RE: CU-26-00003 Ranch at Rosyln Ridge

RE: CU-26-00003 / SE-26-00007 – Ranch at Roslyn Ridges
SR 903 milepost 7.54 Rt (Patrick Mine Rd) & 7.82 Rt (Ridgecrest Rd)

Re: Ranch at Roslyn Ridge Conditional Use Permit Application (CU-26-0003) and Associated SEPA Review

SUBJECT: WDFW COMMENTS ON CU-26-00003 & SE-26-00007 RANCH AT ROSLYN RIDGE

EXHIBIT X4-1 THE RANCH AT ROSLYN RIDGE SCALED SITE MAP WITH IDENTIFIED

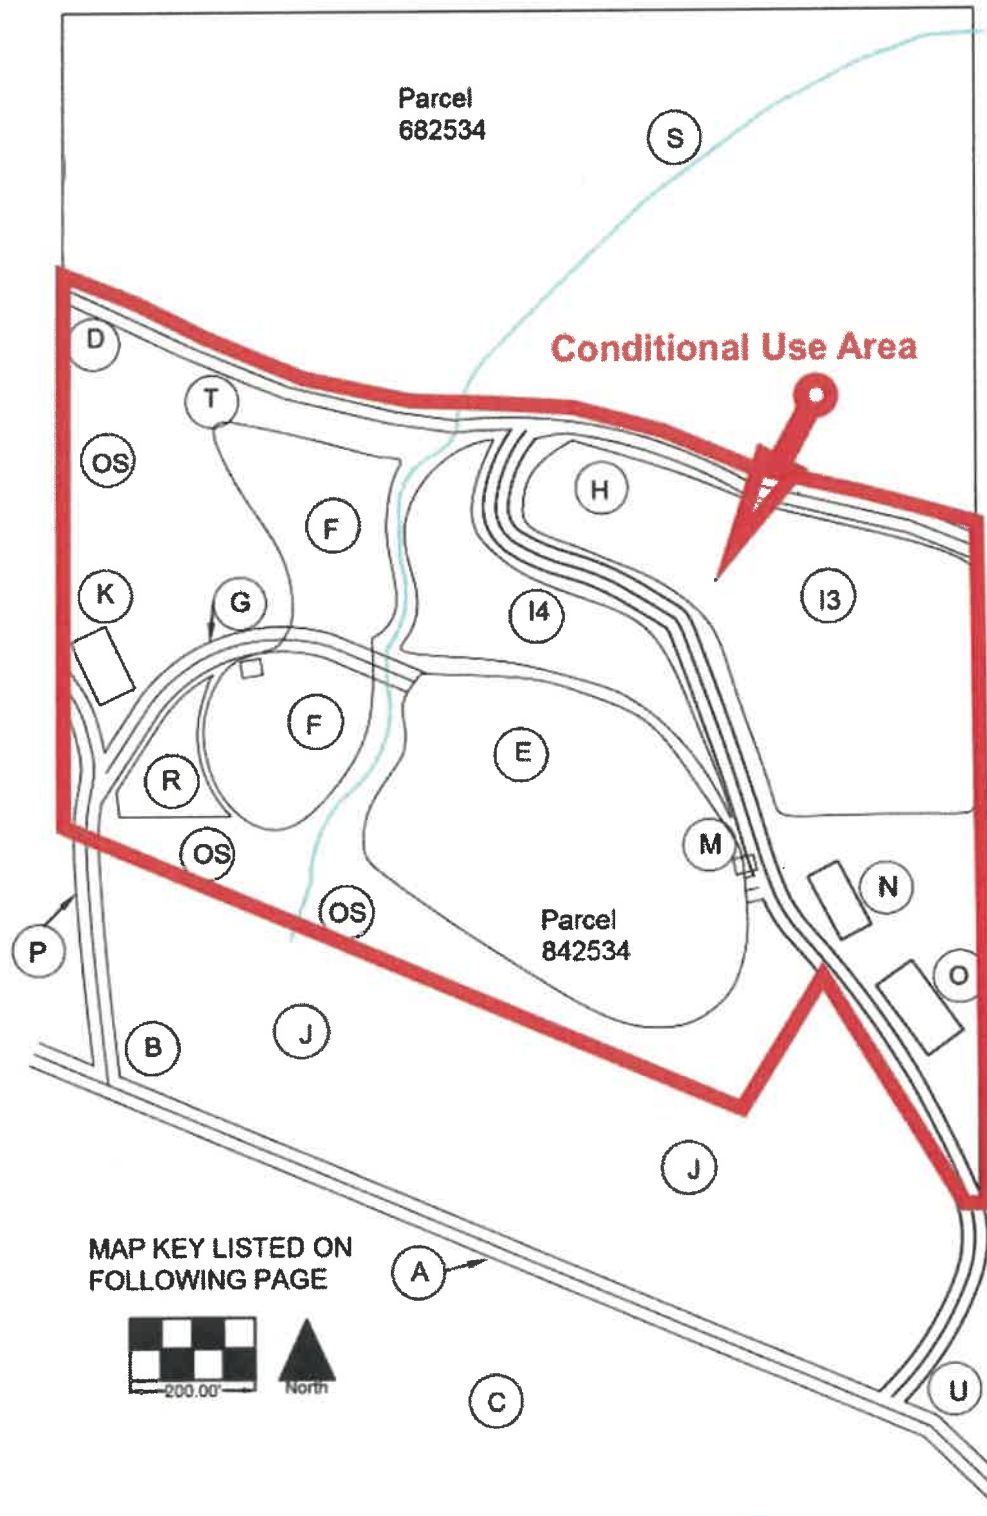
- The stream mapping on the submitted materials does not match what is shown on the DNR stream layer or Kittitas County’s Compas map. WDFW recommends a site visit to confirm stream typing and location of all water courses prior to approval of this application. All watercourses should receive the existing riparian management zone protection in the Critical Areas Ordinance (Table 17A.04.030.6).

- WDFW appreciates that most of the area proposed for this conditional use is already somewhat disturbed habitat. The northern portion of parcel 682534 is not shown as part of this conditional use application and this forested habitat provides important wildlife habitat and connectivity for multiple species despite the existing trail network on the property. If this trail network will be improved, accessed, or is advertised as part of the Guest Ranch, we believe it should be included in this review process. The potential for increased year-round motorized use in this area associated with the Guest Ranch proposal is likely to compromise wildlife connectivity and wildlife habitat and these impacts may not be adequately mitigated for as currently proposed.
